Further Information Response (P. Ref. 24/60545)

**Proposed Sand & Gravel Pit Extension, Mounthall &
Cummer townlands, Camross, Co. Laois**

Breedon Materials Limited (trading as Breedon Ireland)

1 May 2025

Figure 4-2: Receptor Location Map

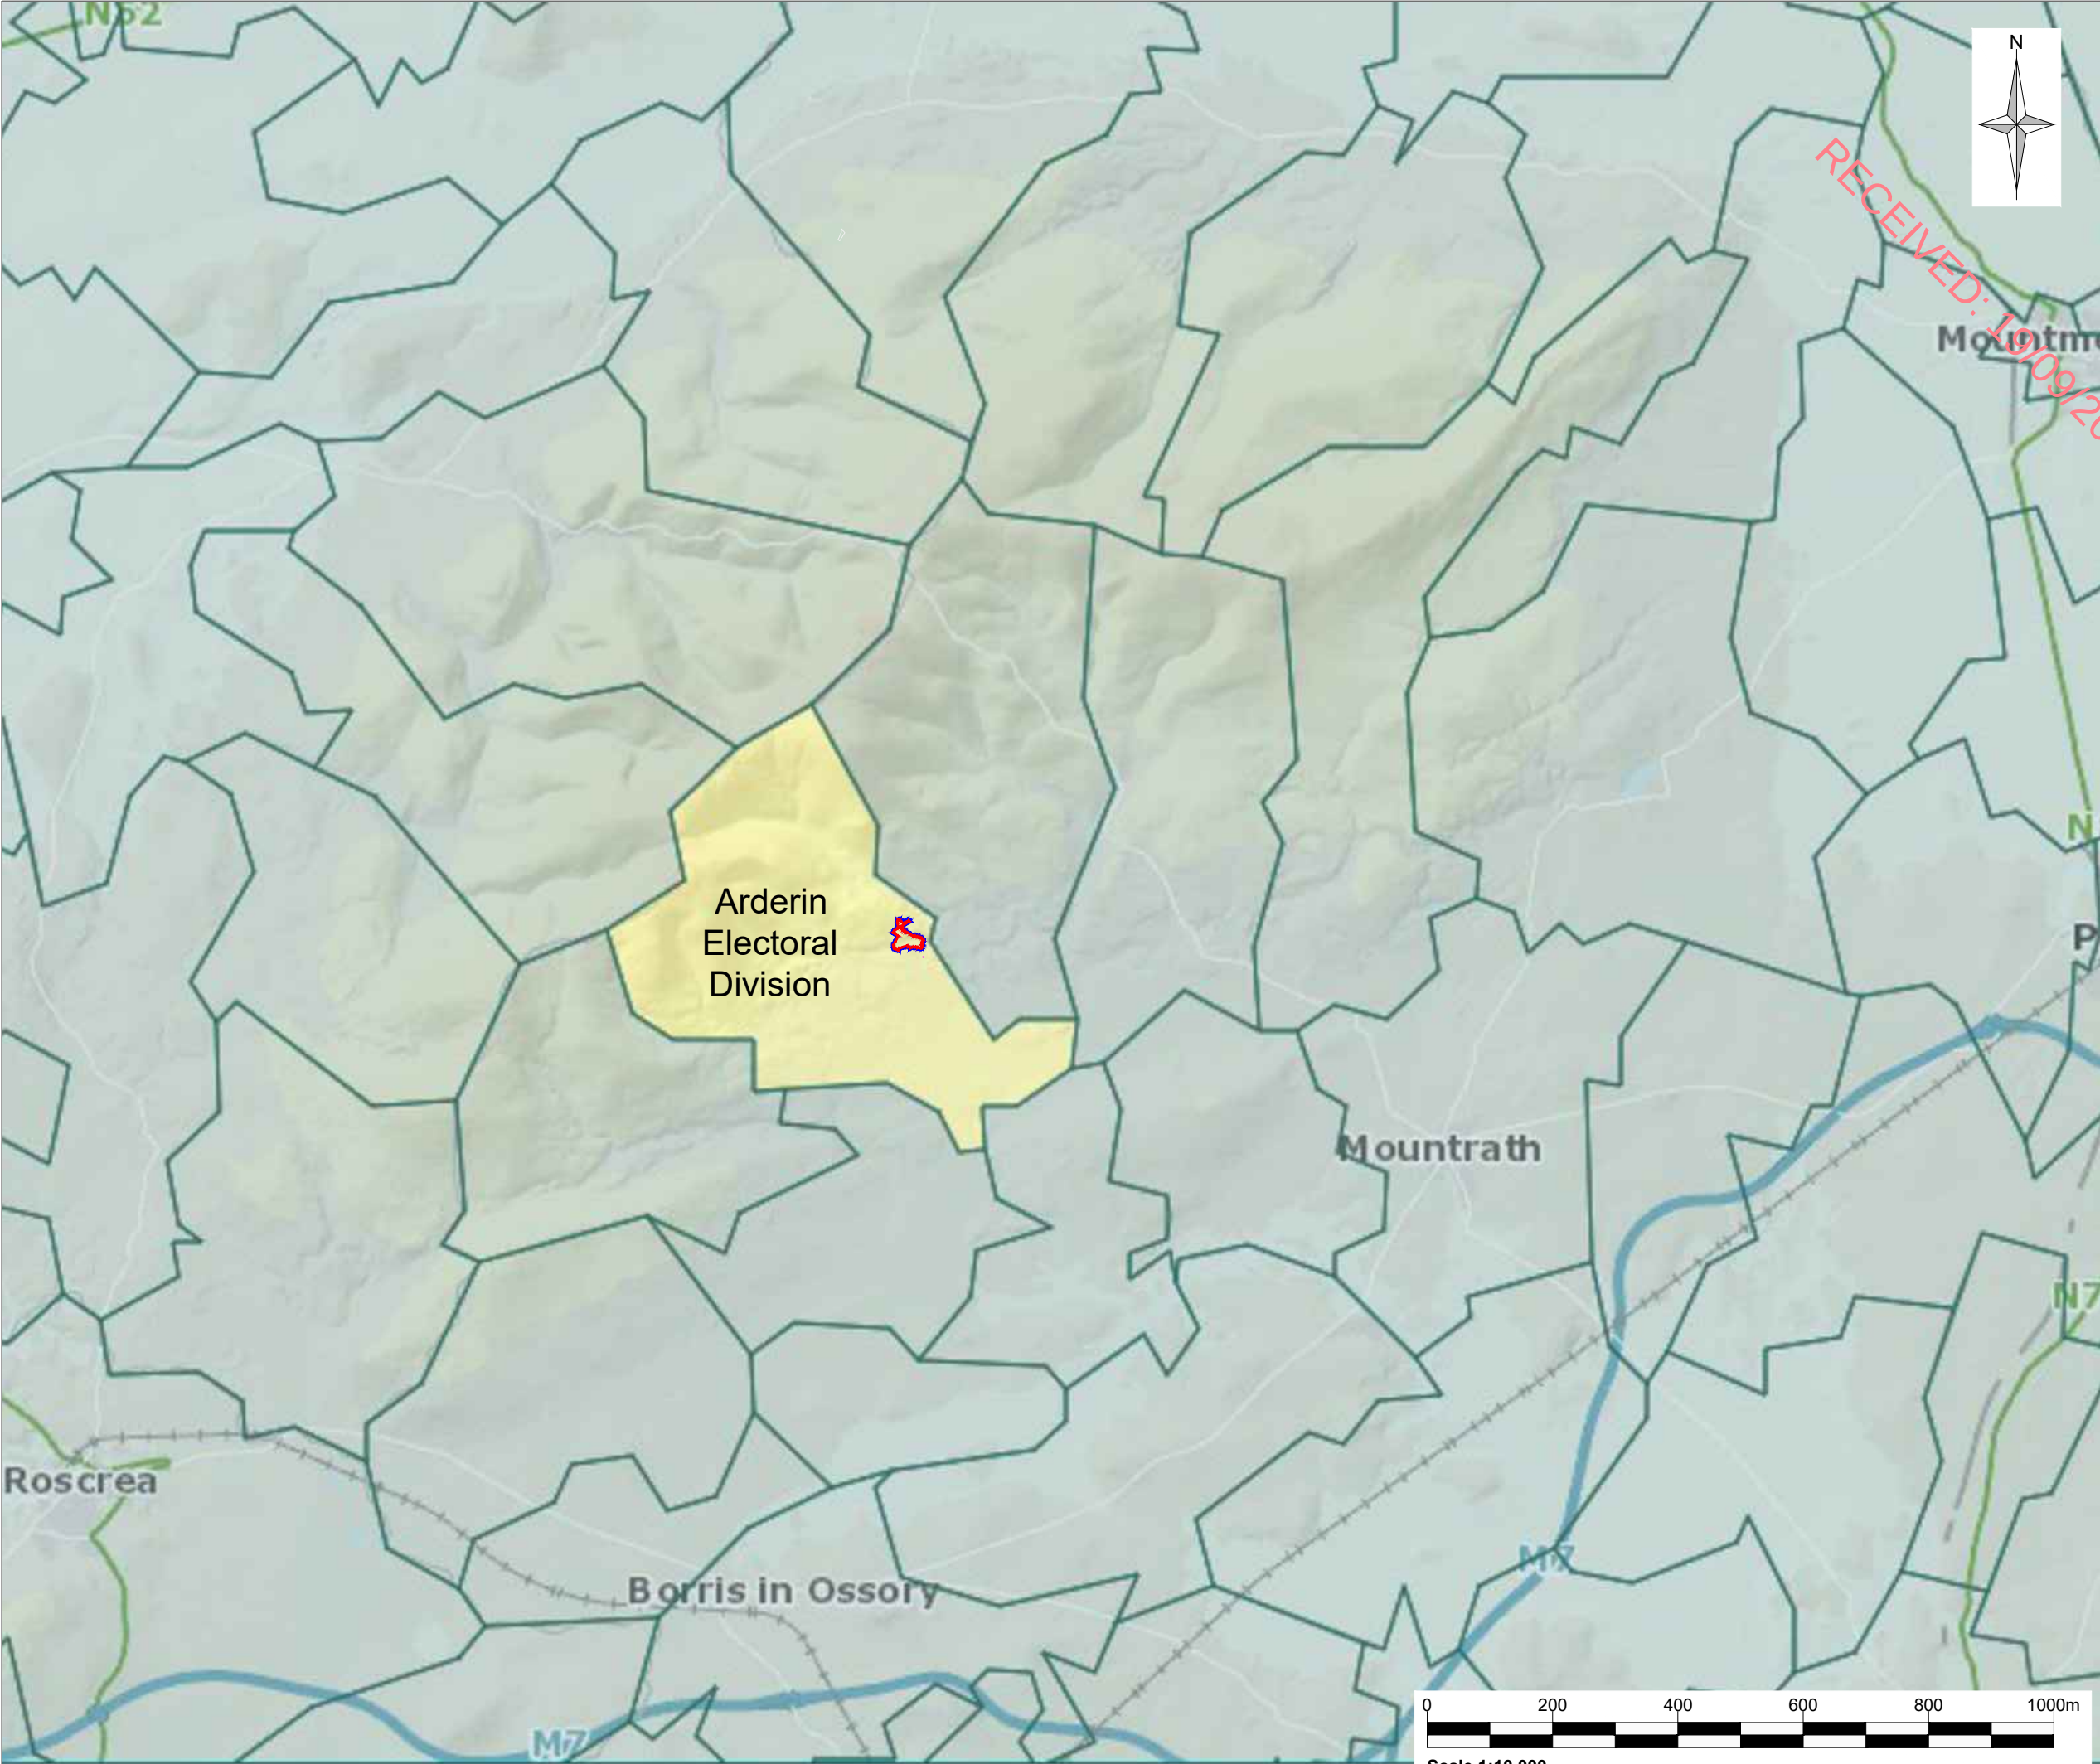
- a) The proposed extraction works are referred to as 40m east of the R1 receptor. However, it is to the west / south west of the receptor.
- b) The proposed extraction would be to the east of R3 residence. However, it will be west of R3.

The Planning Authority notes that Chapter 4 refers that there are 21 no. sensitive residential receptors within 500m of the application site.

However, this contradicts with some other chapters, which refers to 20 no. sensitive receptors within 500m.

The applicant is requested to review and confirm, and, where necessary updating each respective chapter for consistency.

EIAR Chapter 4, at paragraph 4.64 incorrectly states:

"R1 is 25m east of the application site, but is closest to the proposed extraction works, which will be 40m east of the receptor at the nearest point. R1 is the landowner's residence."

The above paragraph should state:

"R1 is 25m east of the application site, but is closest to the proposed extraction works, which will be 40m west / southwest of the receptor at the nearest point. R1 is the landowner's residence."

Table 3-1 below summarises the receptors located within 1km of the site and their distances from the red line application boundary. **Plate 3-1** (extract from EIAR Figure 4-2) below shows the receptor (residence) locations plotted at a scale of 1:10,000. Owing to the scale of the mapping and the annotation of the receptor number being a size that is legible to the reader, R21 is showing overlaying the 500m off-set distance boundary, even though it lies just outside the 500m radius at a distance of 505m. It is for this reason it is included in the count of residences within 500m.
